## **PLANNING REFERENCE 21/02913/FUL**

### **LAND AT DUCK END FARM, PARK LANE, DRY DRAYTON, CB23 8DB**

Please find attached to this letter a Non-material amendment (S96A) application which follows the grant of planning permission 21/02913/FUL in December 2021.

project number drawing number revision
0488 112 g

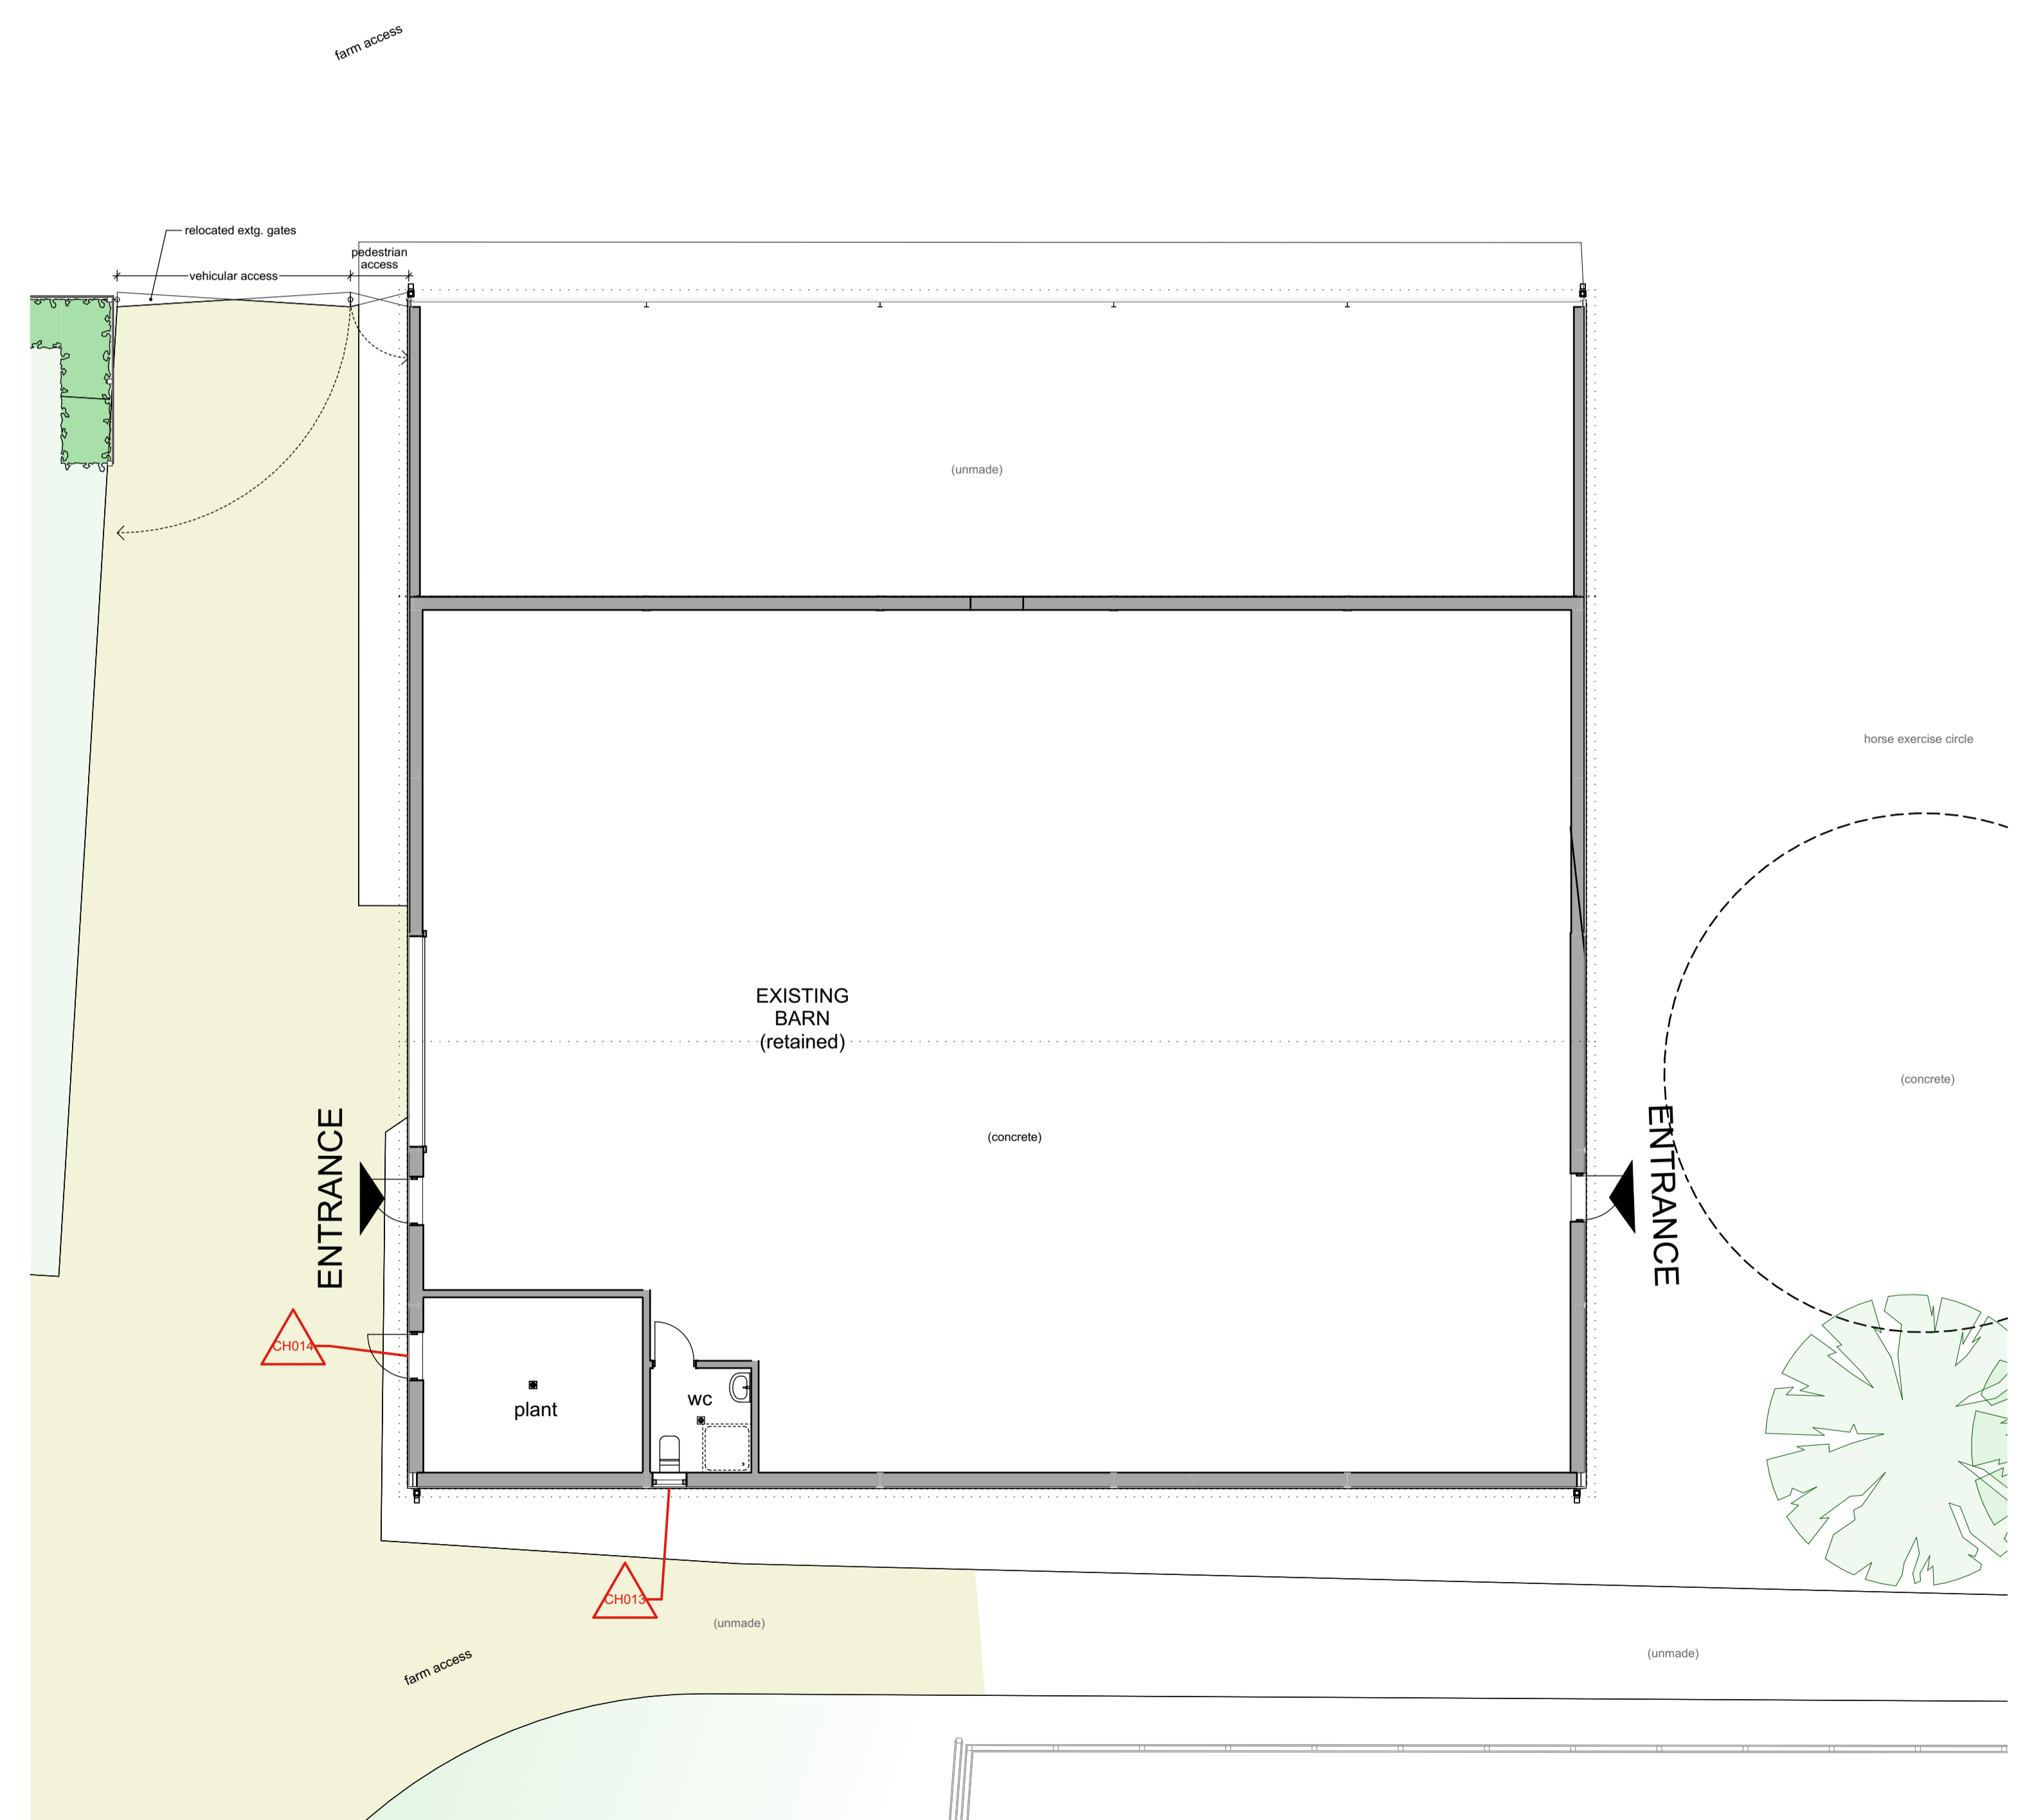
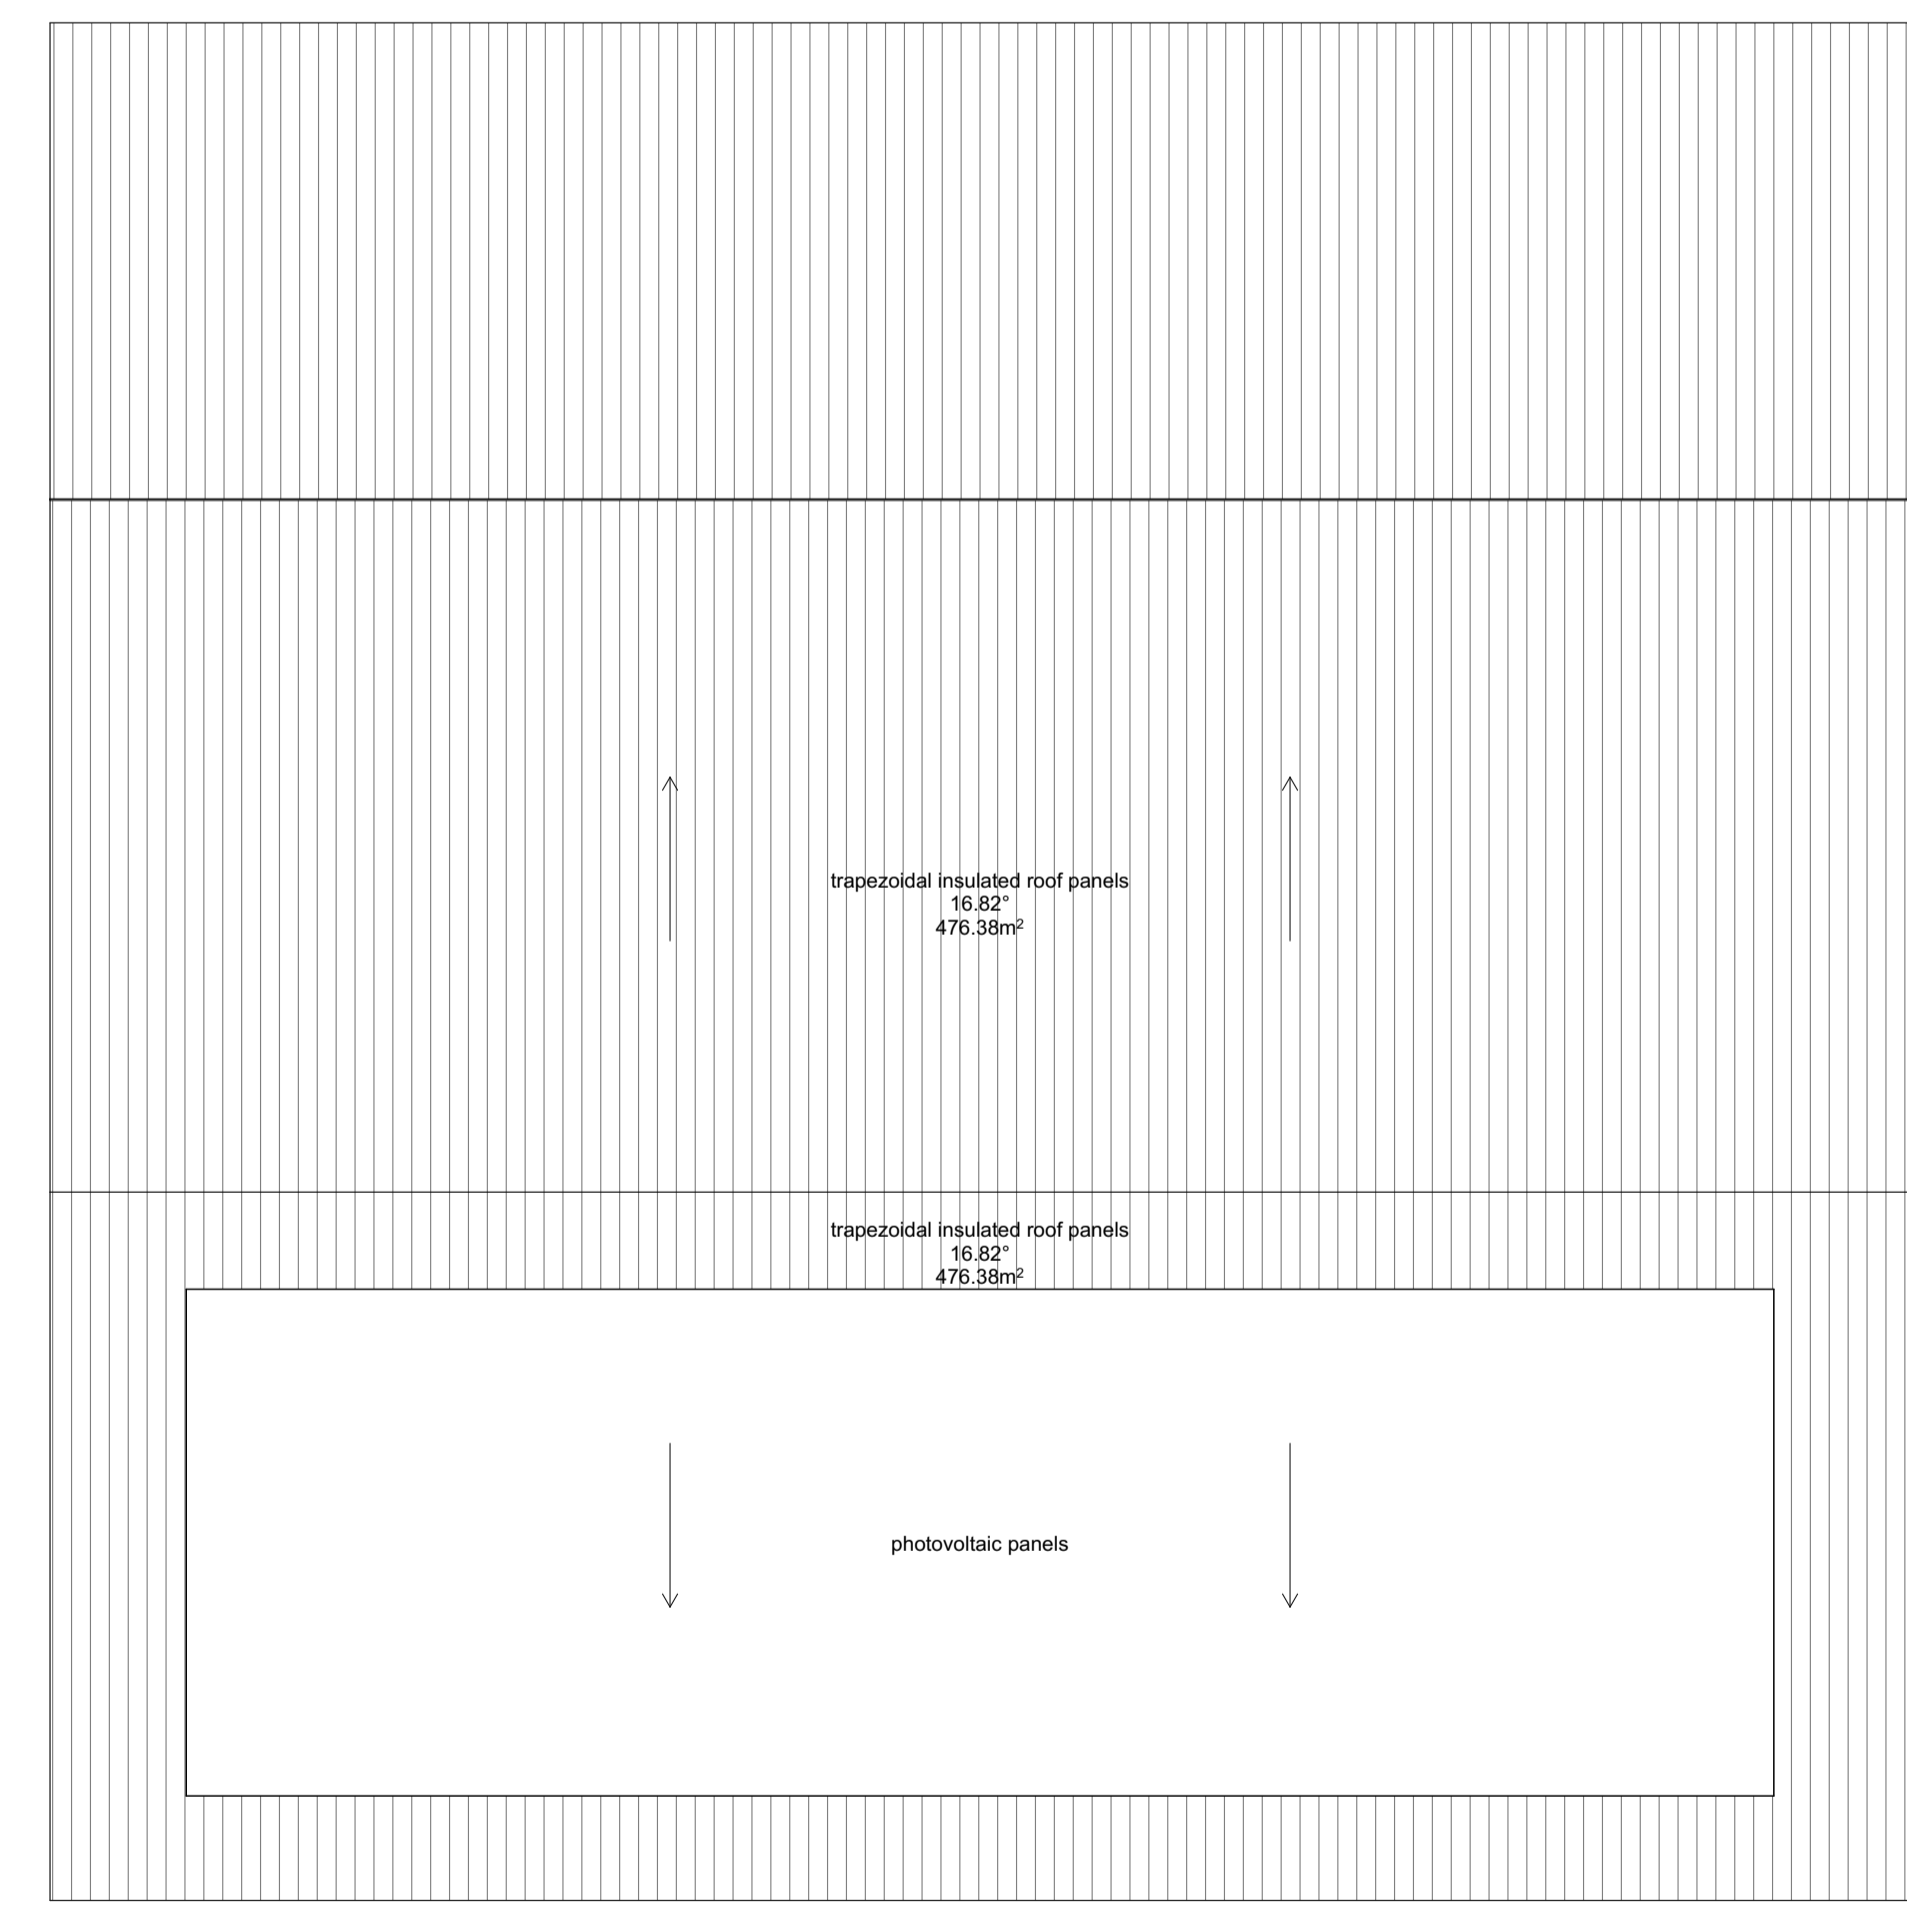
- Change in finish of the roof from timber cladding to a standing seam zinc, coloured in dark grey. This will match the proposed cladding.
- Addition of a door to the barn for plant room access.
- Window size/ lateral position adjustments to fit selected cladding system.
